Application No: EP/22/21/HH
Site Address: 15 The Plantation East Preston BN16 1LD
Description of works: Erection of rear extension and loft conversion with rear dormers and side gables

Thank you for your internet representation made on 21st April 2021 which has been recorded as an objection with the comments as follows:

Planning Application EP/22/21/HH 15 The Plantation, East Preston BN16 1LD

8 East Facing front Elevation

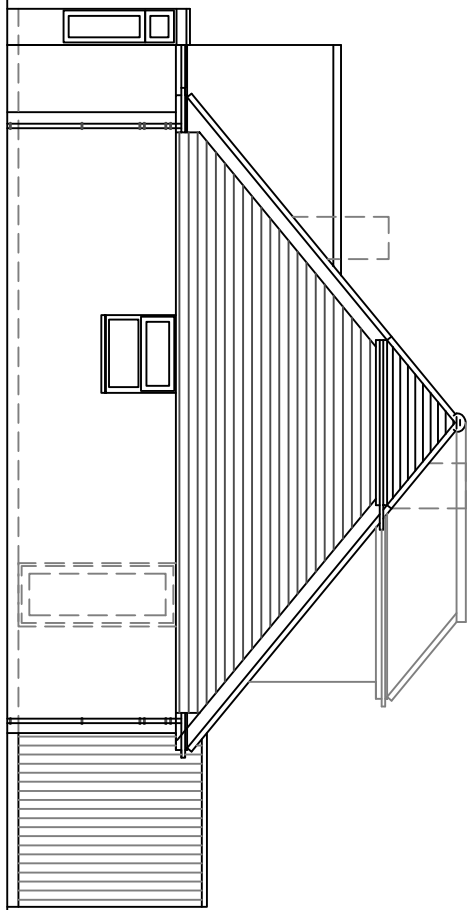
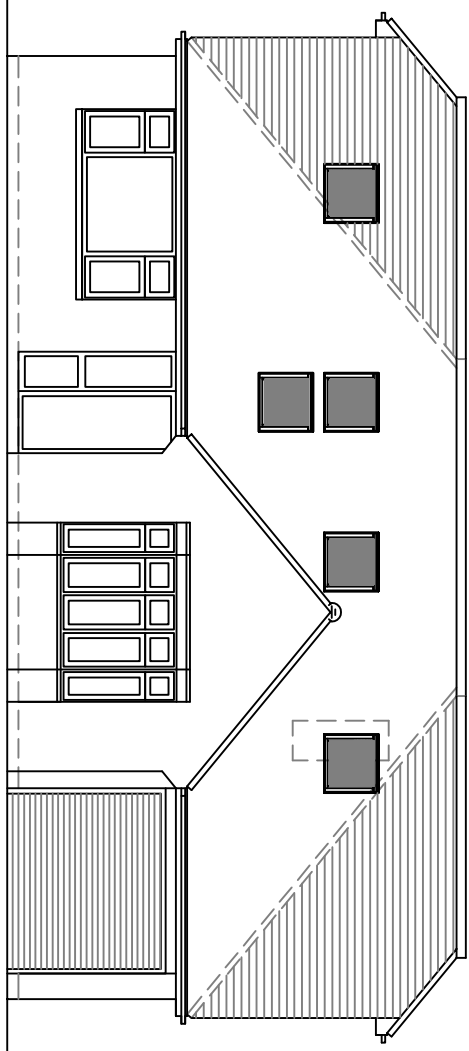
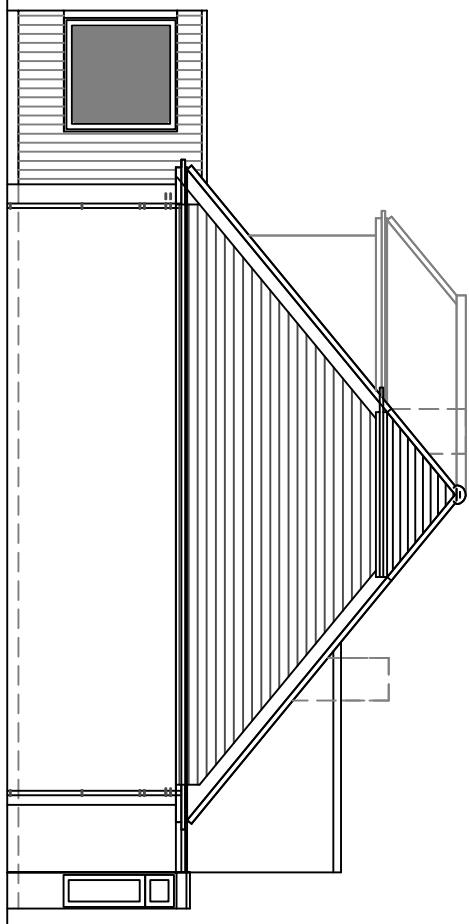
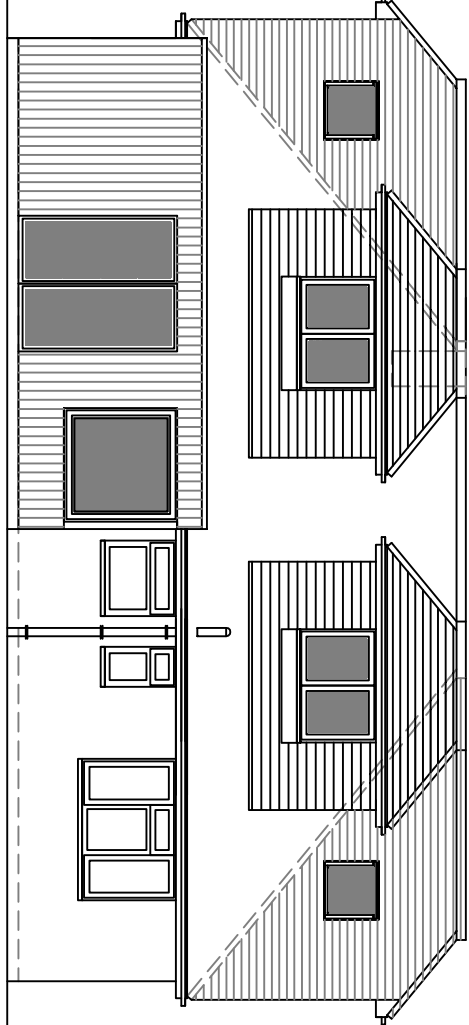
There is an excess of unsightly Velux type windows to the front (eastern) elevation; the light from which will pollute the dark unlit area.

To the rear of rear (west) elevation there are two excessively large dormer windows as well as another two Velux windows.
